1865 Woodmoor Drive - As Built
Existing Retaining Wall Heights

Sunshine Behavioral Health
1865 Woodmoor Drive
Monument, CO 80132

As-Built Exg
Retaining Wall Plan

As-Built Exg
Retaining Wall Plan

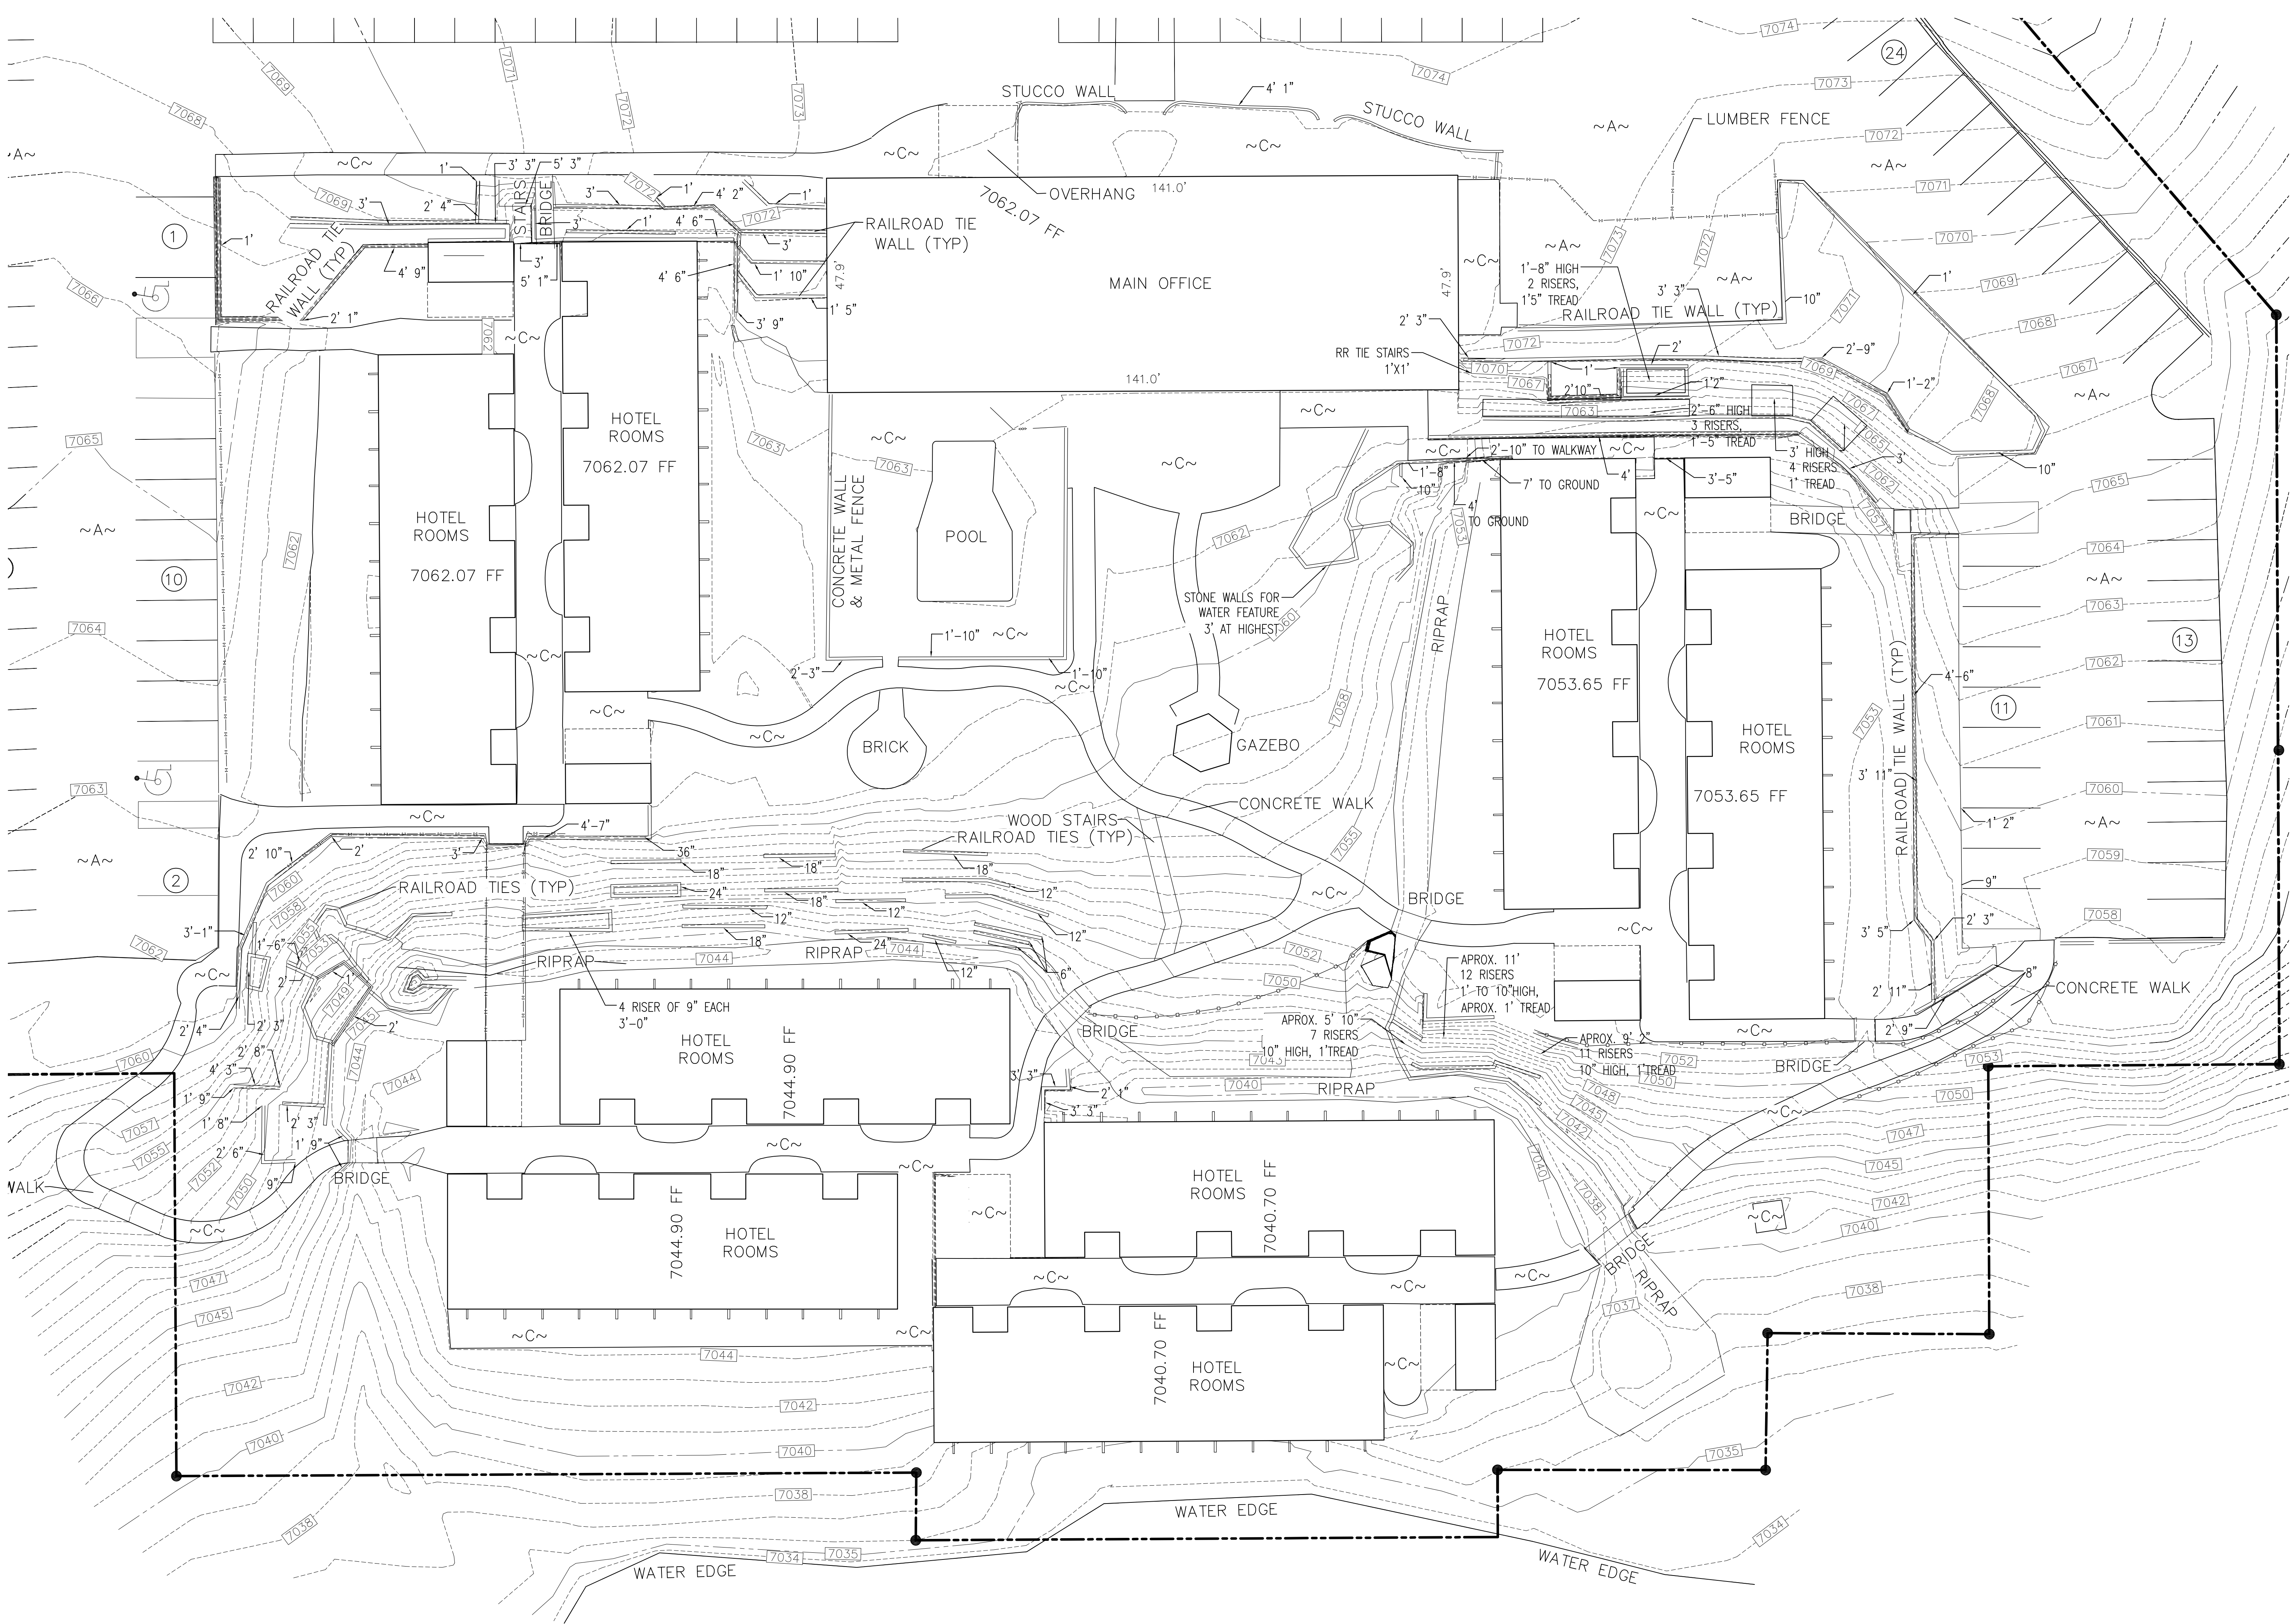
Provide proof that Pikes Peak Regional Building Department either has building permits for the retaining walls over 4 feet in height, or proof that they do not want them.
